### **Crime Impact Statement**

Planning Application 3/2017/0220 - application for Full Consent for a change of use from a shop to a food takeaway at 2A Whittingham Road, Longridge, PR3 3JA. (Opening hours 4pm – 11pm Mon-Sun Inc. Bank Holidays).

PREPARED SHOP FLOOR PLAN

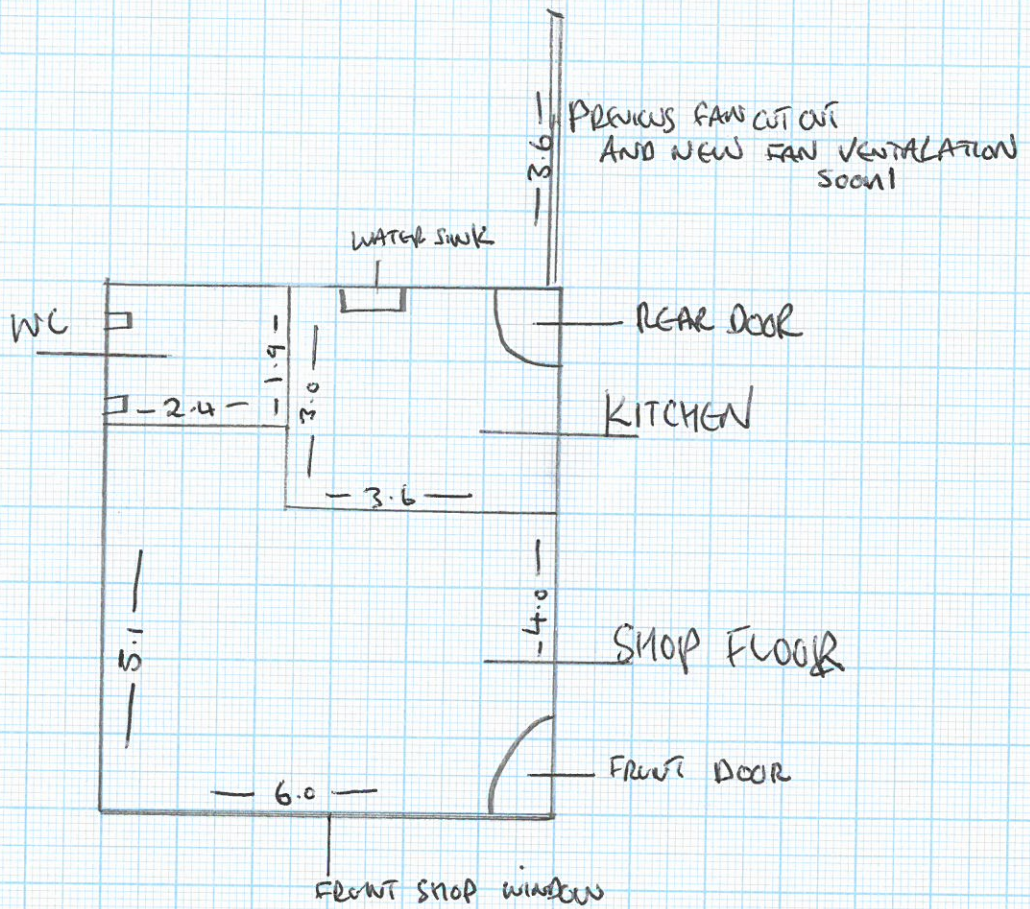
3. The service counter should be high and wide with access restricted to the staff area to reduce the risk of aggressive customers reaching over to intimidate or assaulting staff.

4. Any internal seating and tables should be securely fixed to the floor.
5. External glazing in windows and doors should be laminated.
6. There have been a large number of reported thefts and burglaries at building sites across all areas of Lancashire. High value machinery, white goods and boilers are targeted as the premises near completion. This is placing additional demand on local policing resources. Therefore, the site must be secured throughout the redevelopment phase.
